Grandview Reserve, Filing No. 1, SF-23-11

Please accept the following comments from El Paso County Public Health regarding the project referenced above:

Mike McCarthy
El Paso County Public Health
719-332-5771
mikemccarthy@elpasoco.com
02August2024

POND E - OUTLET
 STRUCTURE DETAILS

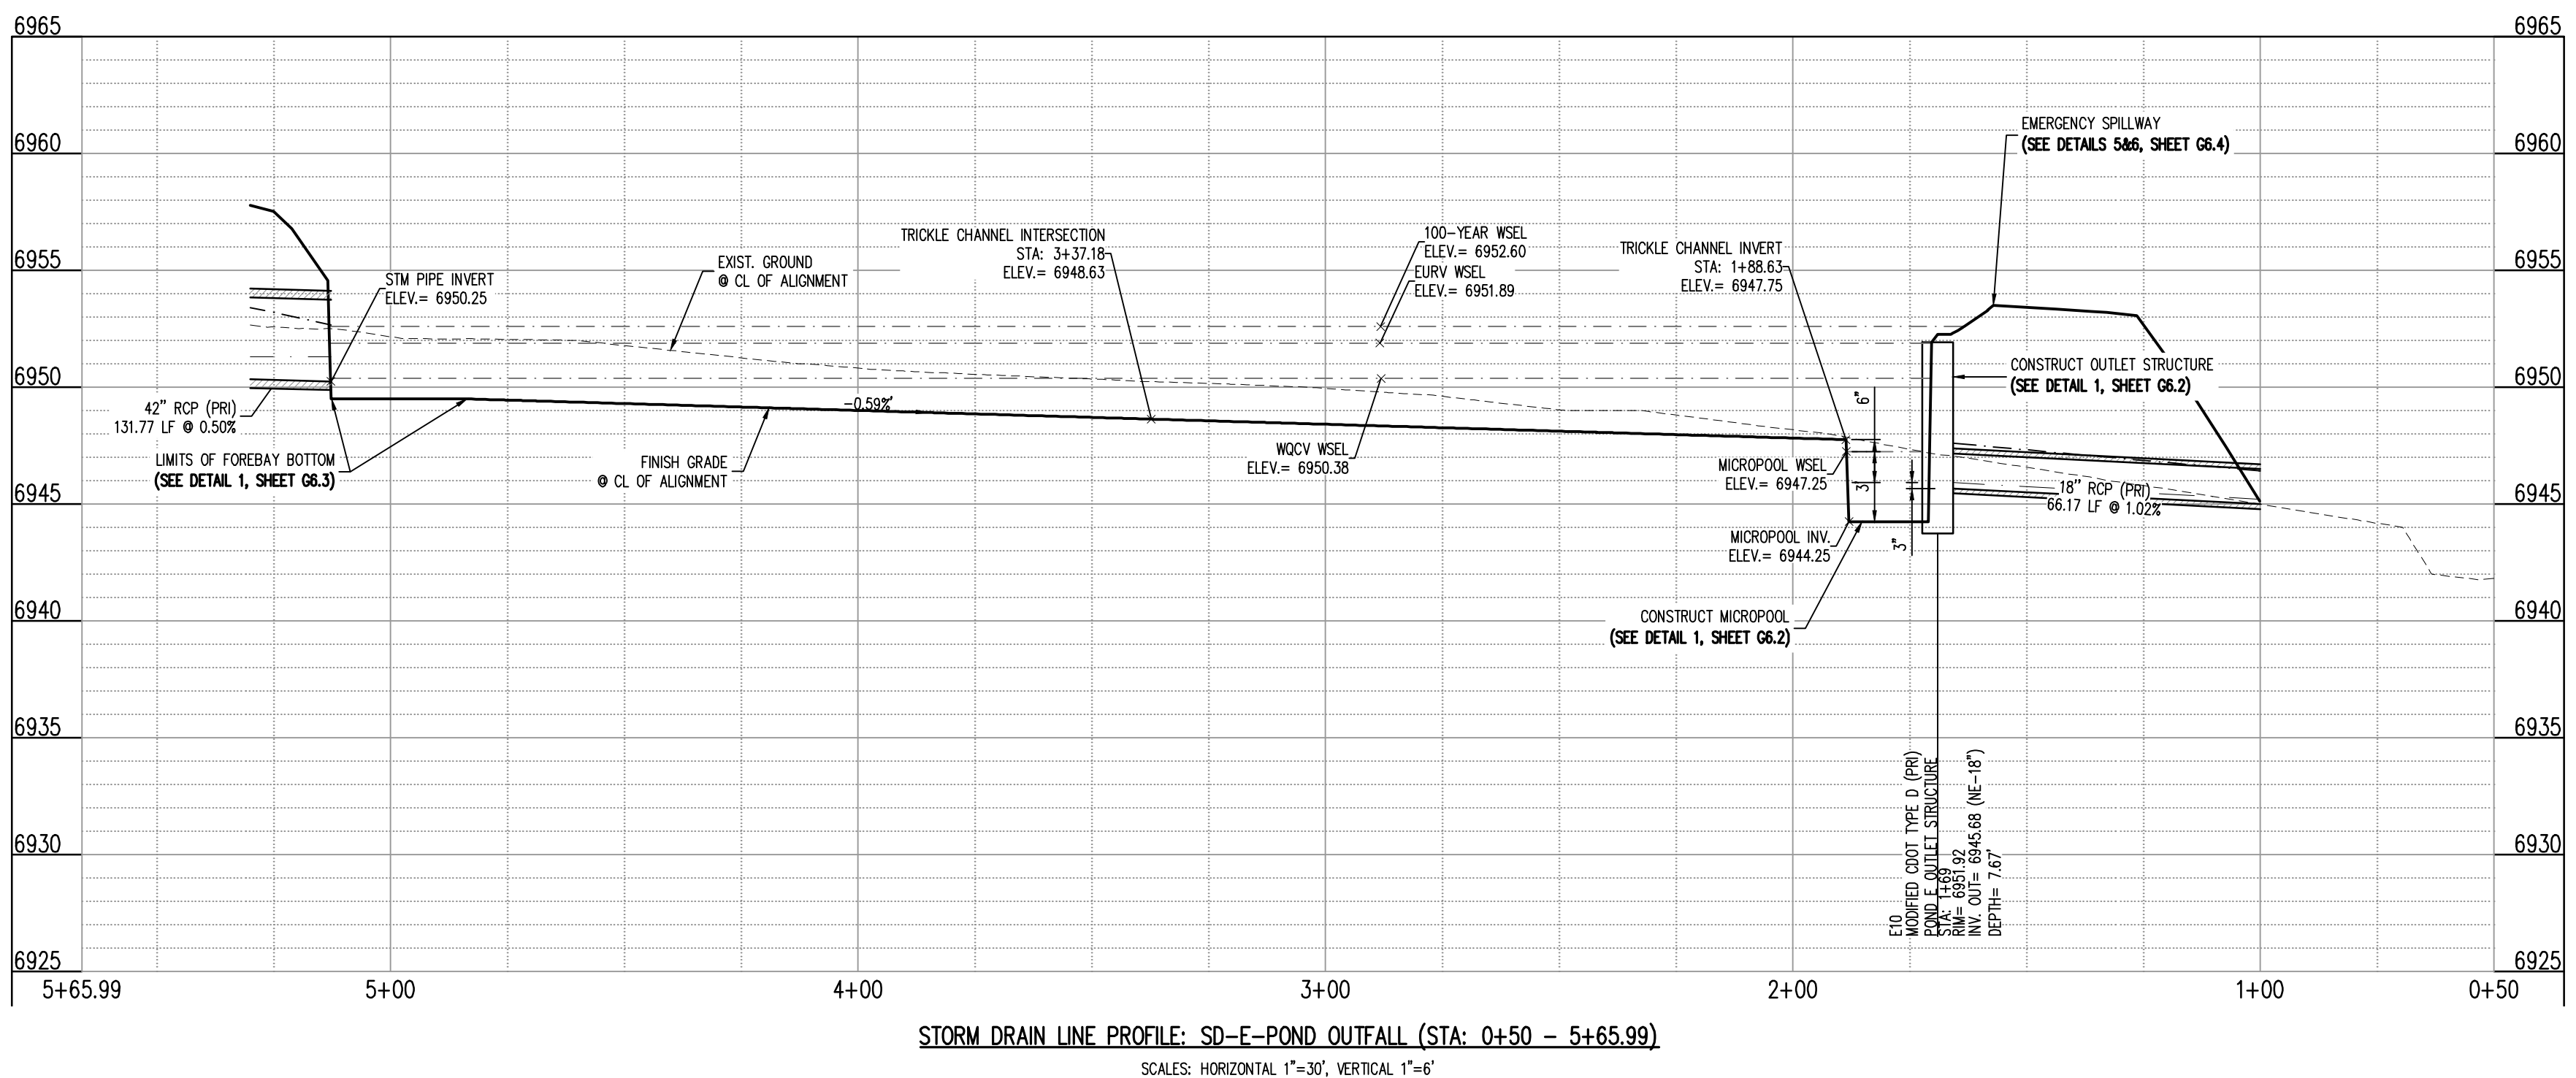
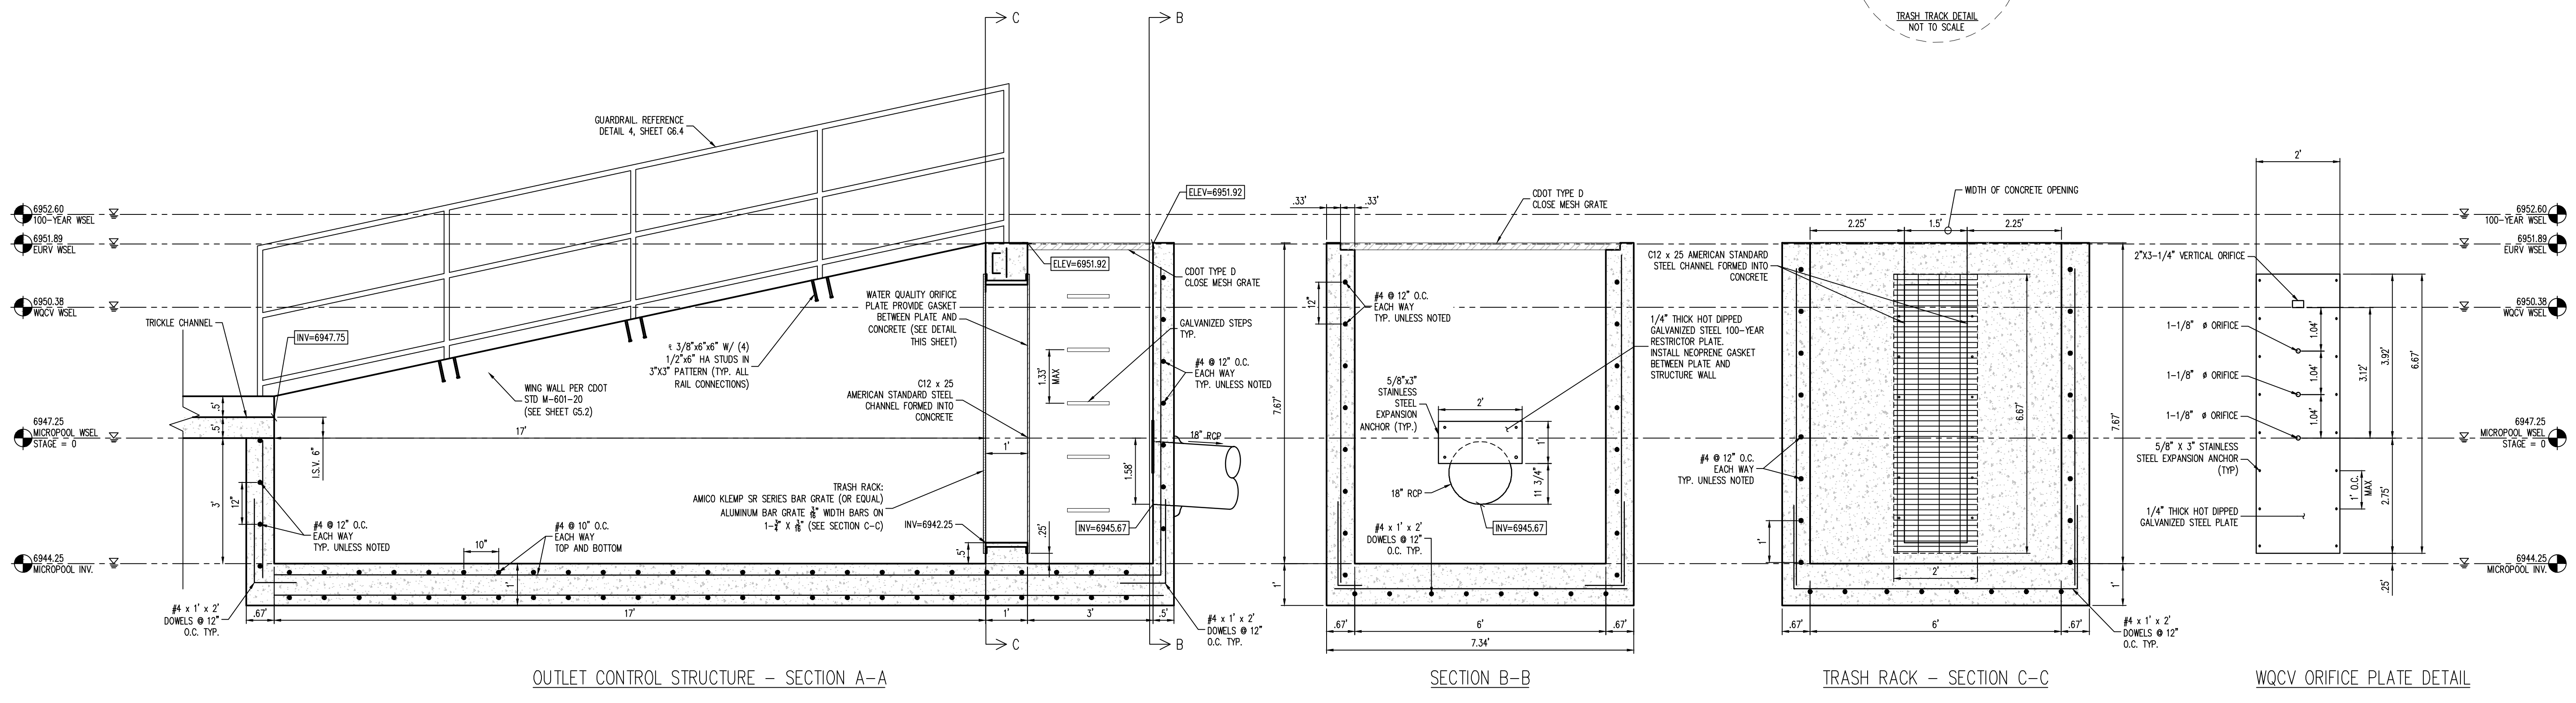
- **The water quality basins must have mosquito control responsibilities included as a part of the construction design and maintenance plan to help control mosquito breeding habitat and minimize the potential for West Nile Virus.**
